Non-material Amendment (Section 96A) Application following approval of Full Planning for the Temporary Siting of Dewsbury Market (2022/48/92308/E)

Foundry Street / Market Place / Longcauseway / Town Hall Way, Dewsbury

Sheet Title  
**Proposed Site Plan**

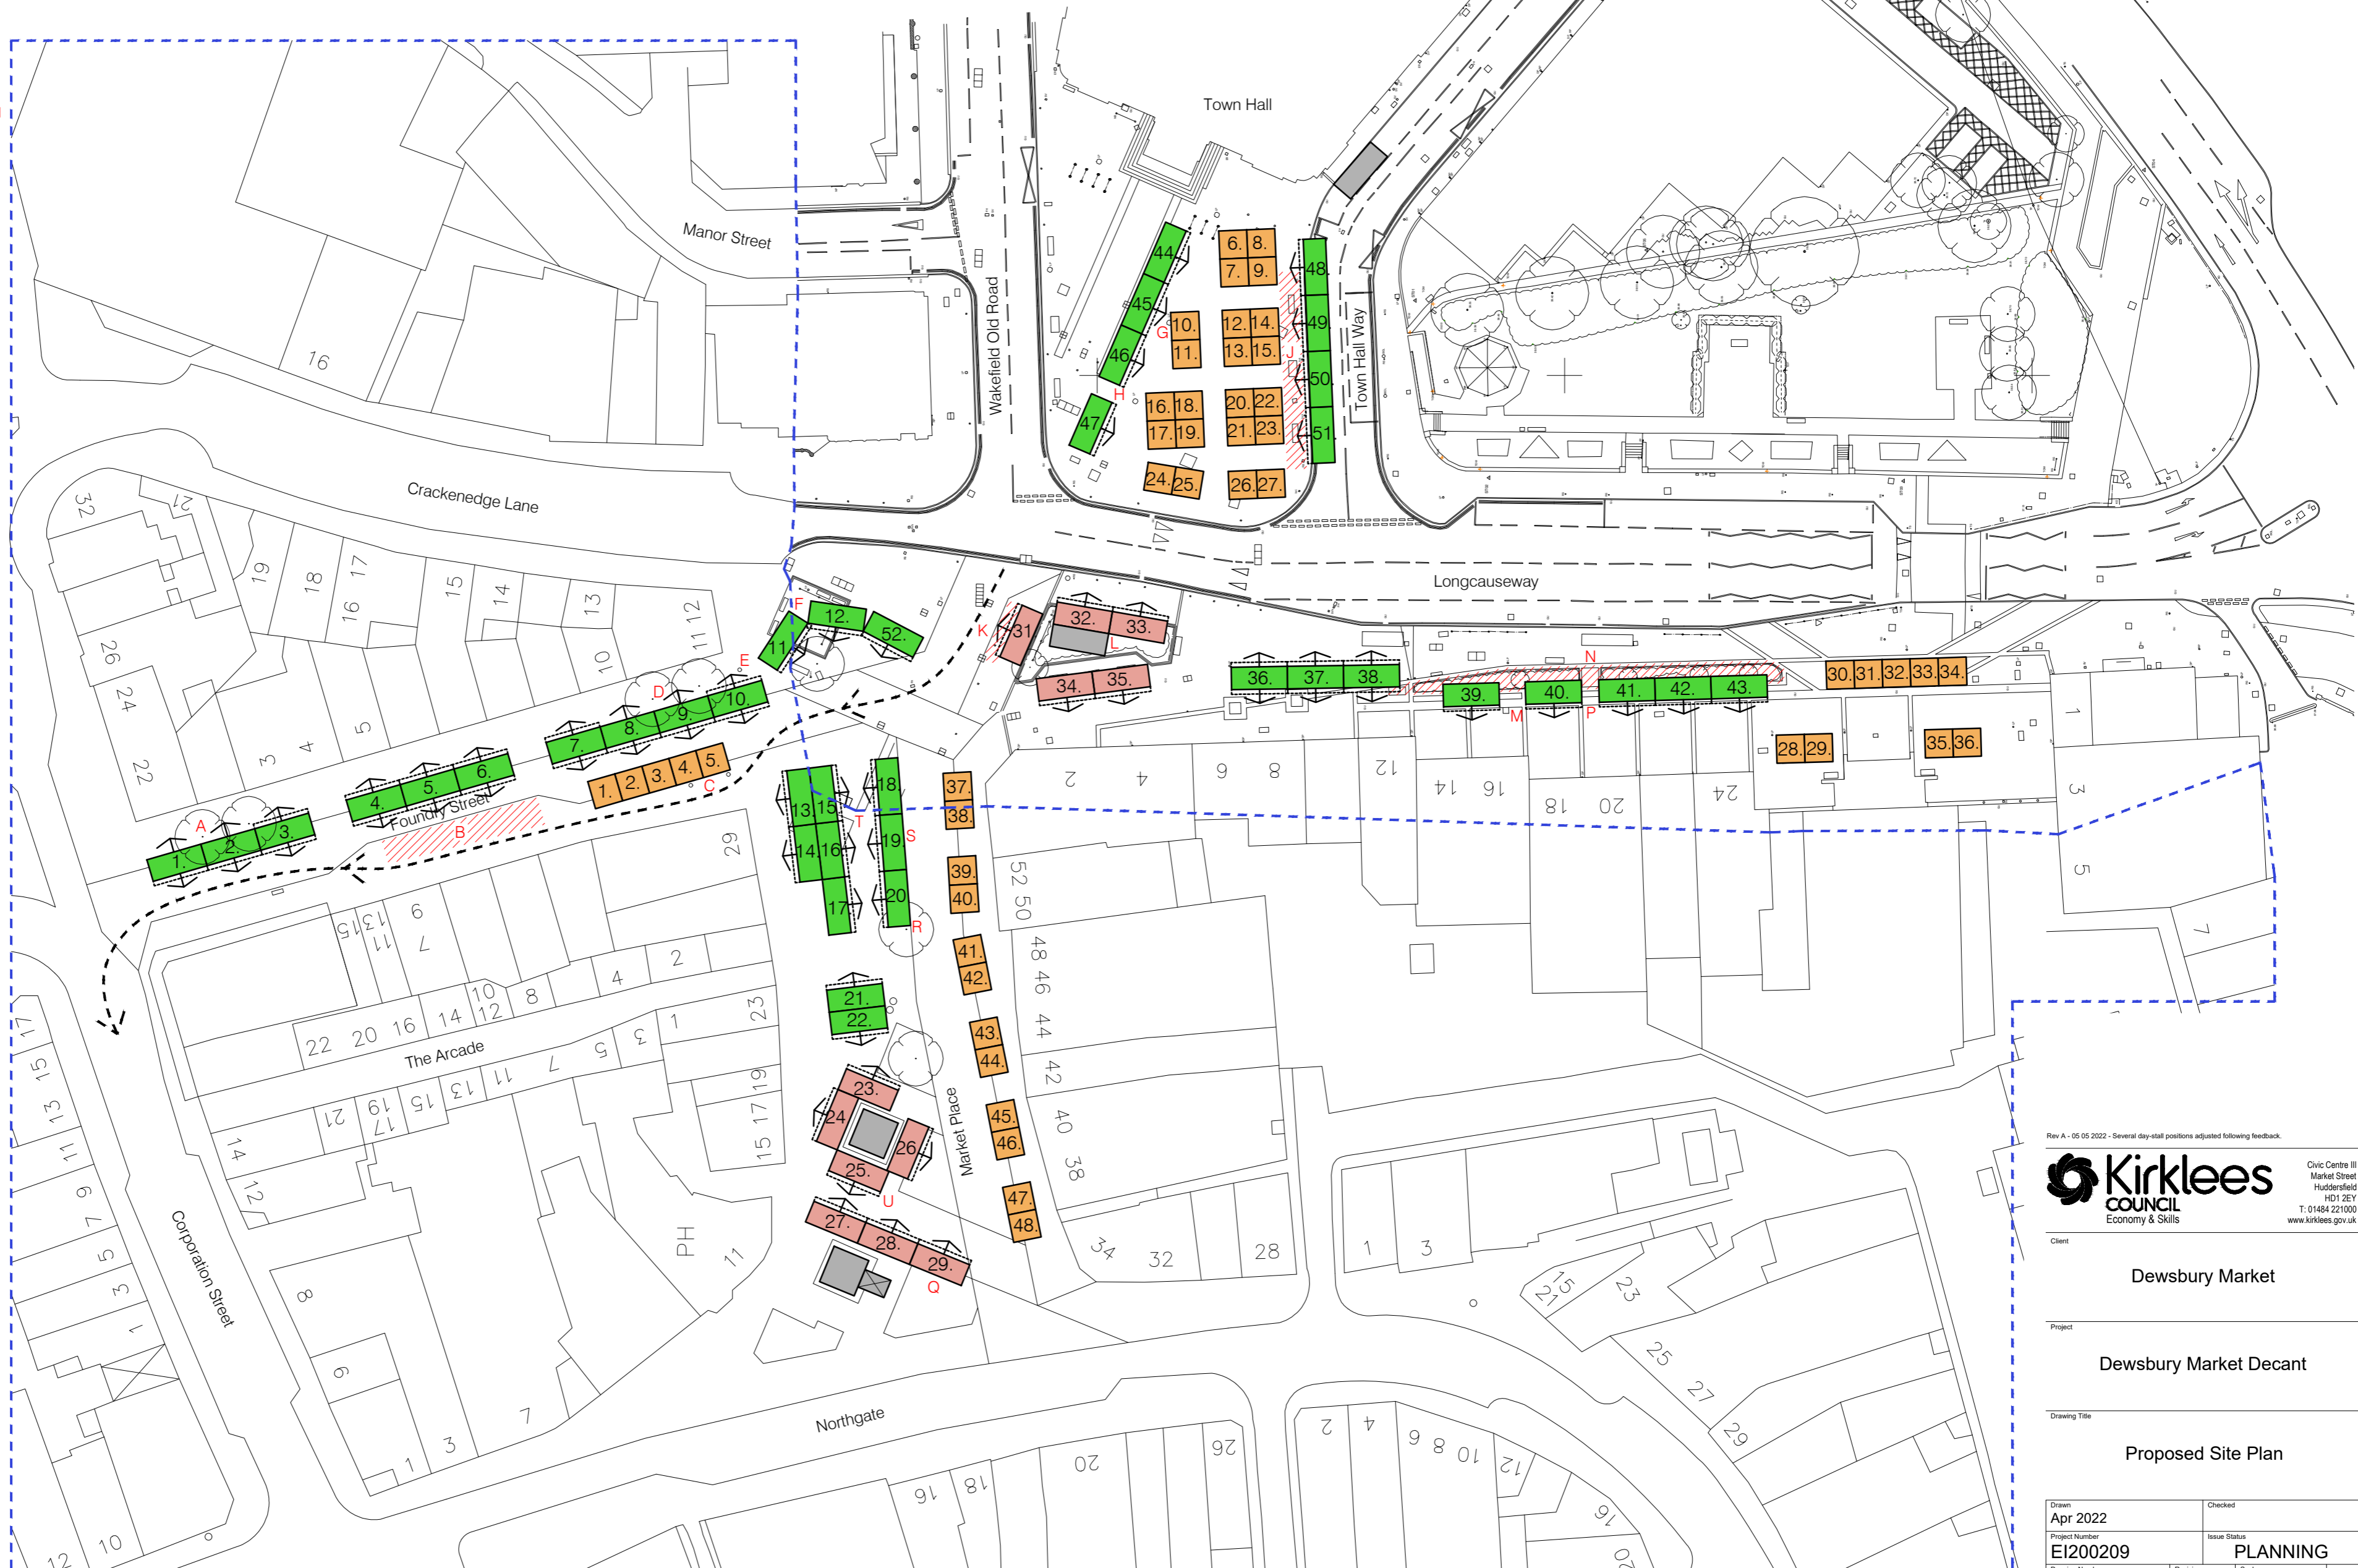
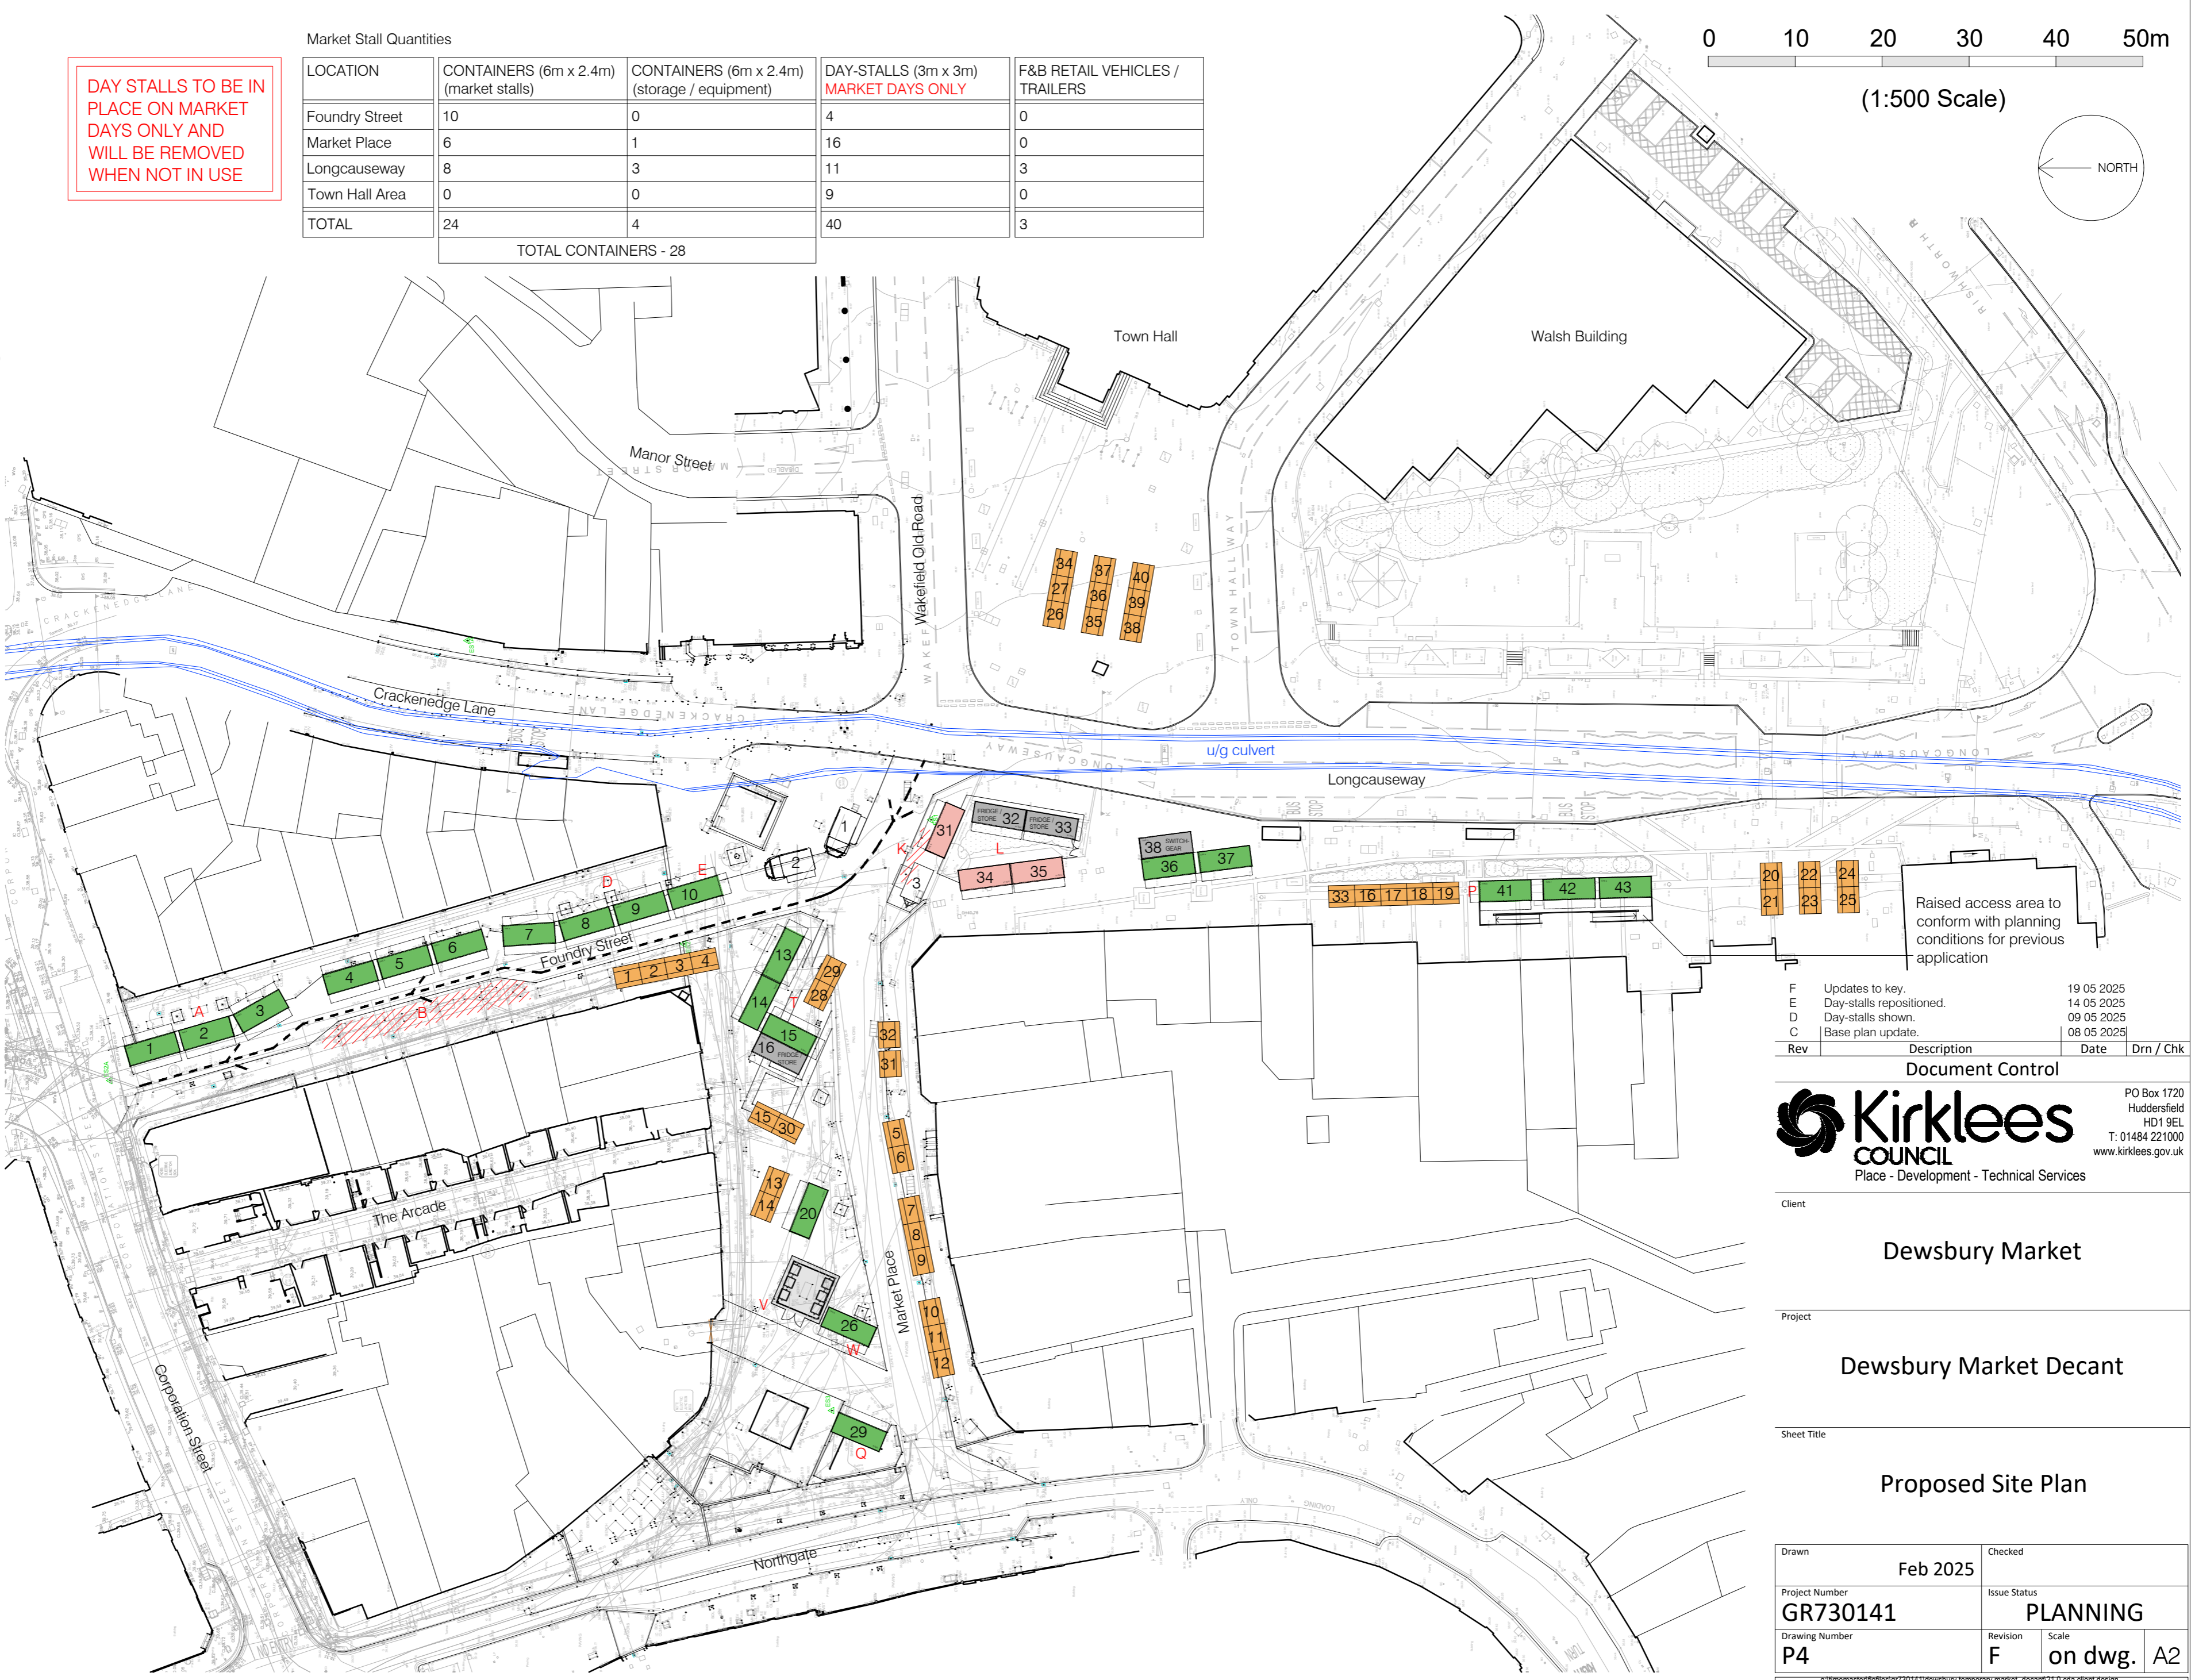
This NMA seeks to reduce the proposed number to 24 container stalls and 4 storage containers (28 total).

The locations of the proposed containers approximately align with those of the approved. There are simply less of them.

The number of containers has reduced due to a change in demand and how the market is currently trading. The proposed layout is based on the discussions with traders and their preferences - of the containers which were approved in clusters (31 to 35, for example), their arrangement has been slightly amended based on traders' requests.

Containers have also been (re)positioned to avoid unnecessary clashes with street furniture and to ensure minimal disruption to the highway – less containers means that less street furniture removal is required. As such, the list of remedial works, listed as points 'A' to 'U' on drawing EI200209 P1 A, has reduced on drawing GR730141 P4 E.

Approved Plan	Replacement Plan	Amendments sought
Proposed Site Plan EI200209 P1 A	Proposed Site Plan GR730141 P4 E	<ul style="list-style-type: none">• Number of stalls reduced from 53 (51 + 2) to 28 (24 + 4)• Some containers slightly relocated, though all remain within the same approximate vicinity as approved• Some clustered containers slightly rearranged, though all remain within the same approximate vicinity as approved• No containers proposed along / adjacent to Town Hall Way• Amount of street furniture removal reduced
